**Laurie Leader - RE: BP#2015-00781 96 Lincoln Street**

**From:** Laurie Leader [mailto:LRL@portlandmaine.gov]  
**Sent:** Thursday, April 30, 2015 2:41 PM  
**To:** Jonathan Block  
**Subject:** BP#2015-00781 96 Lincoln Street

Thanks for responding so quickly to my phone call. As I mentioned, I am handling the building review for 96 Lincoln Street.

96 Lincoln 3rd Floor. Previously Approved
 Top View 7/20/12 2012-05-4076-
 Bathroom Redesign ALTCOMM

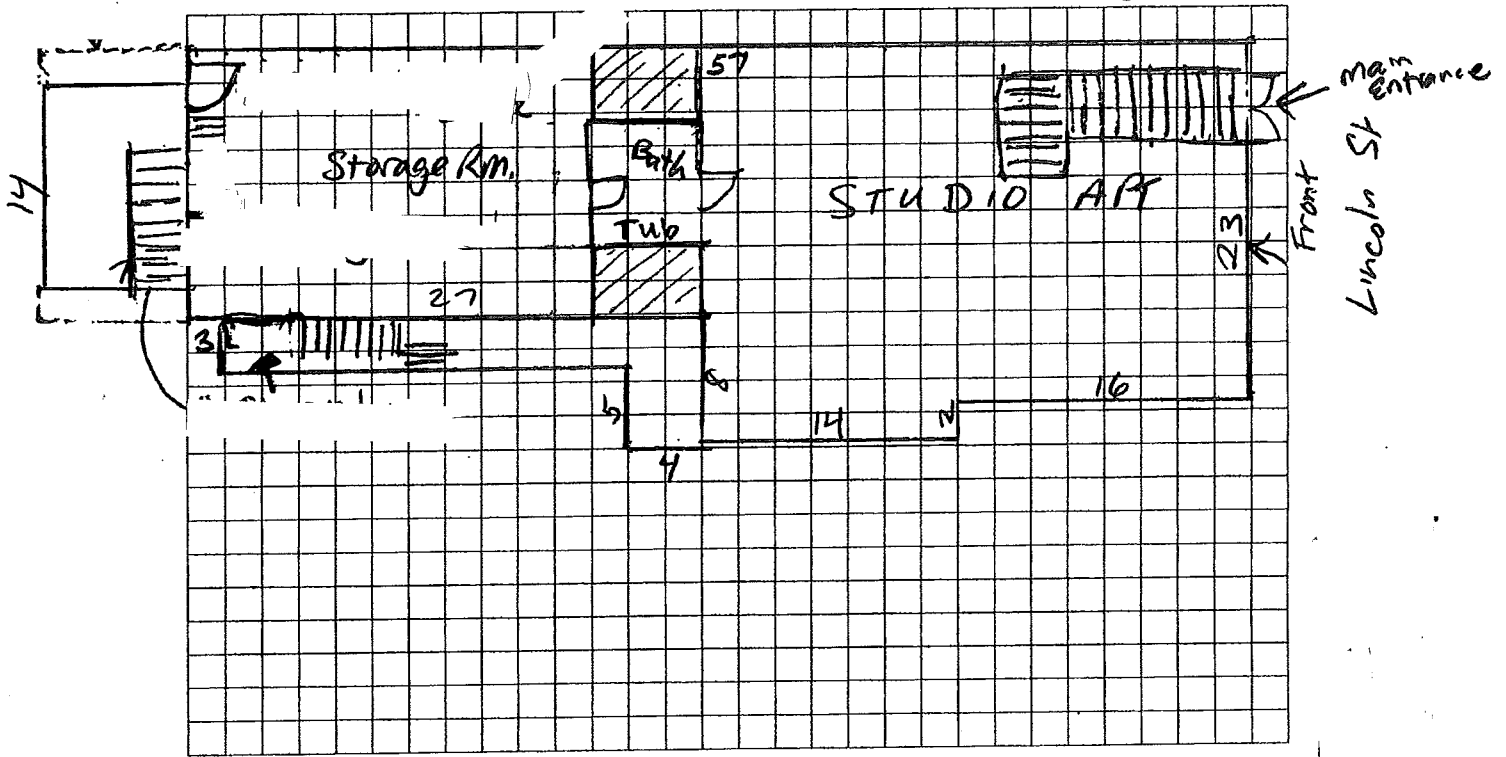
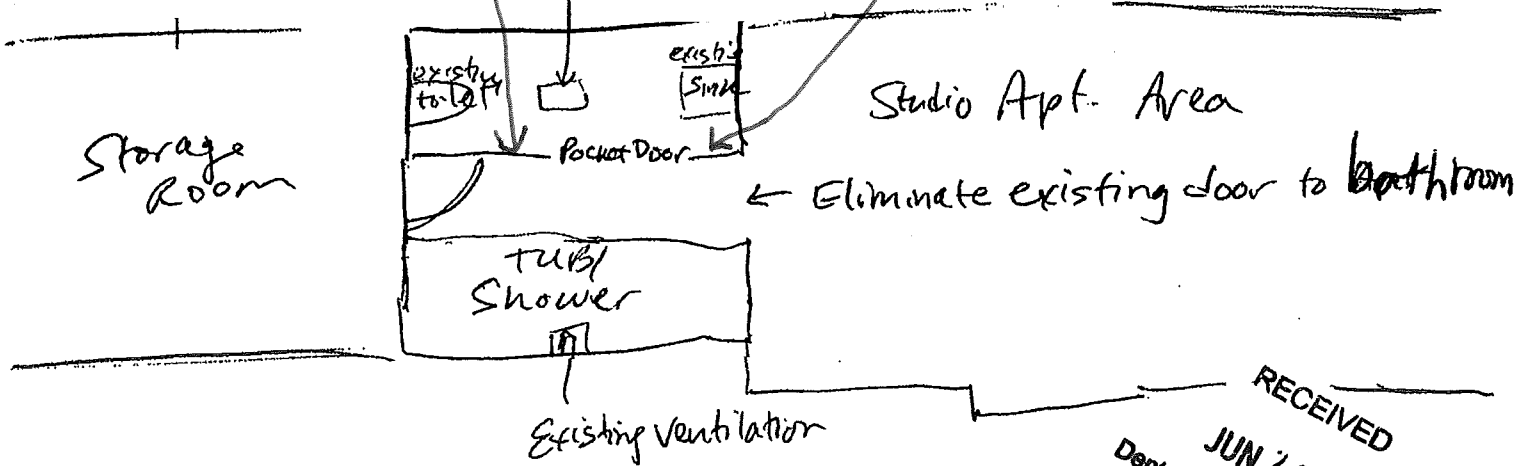
1. It looks like you added a dormer per permit#2012-05-4076-Altcomm. Can you confirm the rear dormer was completed with the fire door but the front stairway was not completed. The work for this building permit was already approved as part of permit#2012-05-4076-Altcomm.
2. Can you confirm the headroom in the proposed stairway meets Section 1009.2 Headroom of the 2009 IBC with minimum headroom clearance of 80 inches?
3. Lastly, ideally the "proposed if possible" stair option would be preferred. I will add a condition for approval in the permit requiring an inspection once the stairway is opened up to confirm if this option is or is not possible.

1. Yes, I confirm that your number 1 is correct. The rear dormer was completed with the fire door but the front stairway was not completed. The work for the current building permit was already approved in the previous building permit you referenced.
2. Yes. Headroom in the stairway is not a problem. However, I will make sure the contractor is aware of the 80 inch requirement.
3. My contractor promises to do the "proposed if possible" version if he possibly can. If you need to add an inspection to confirm it, I guess that will have to be okay. (There wasn't one last time.)
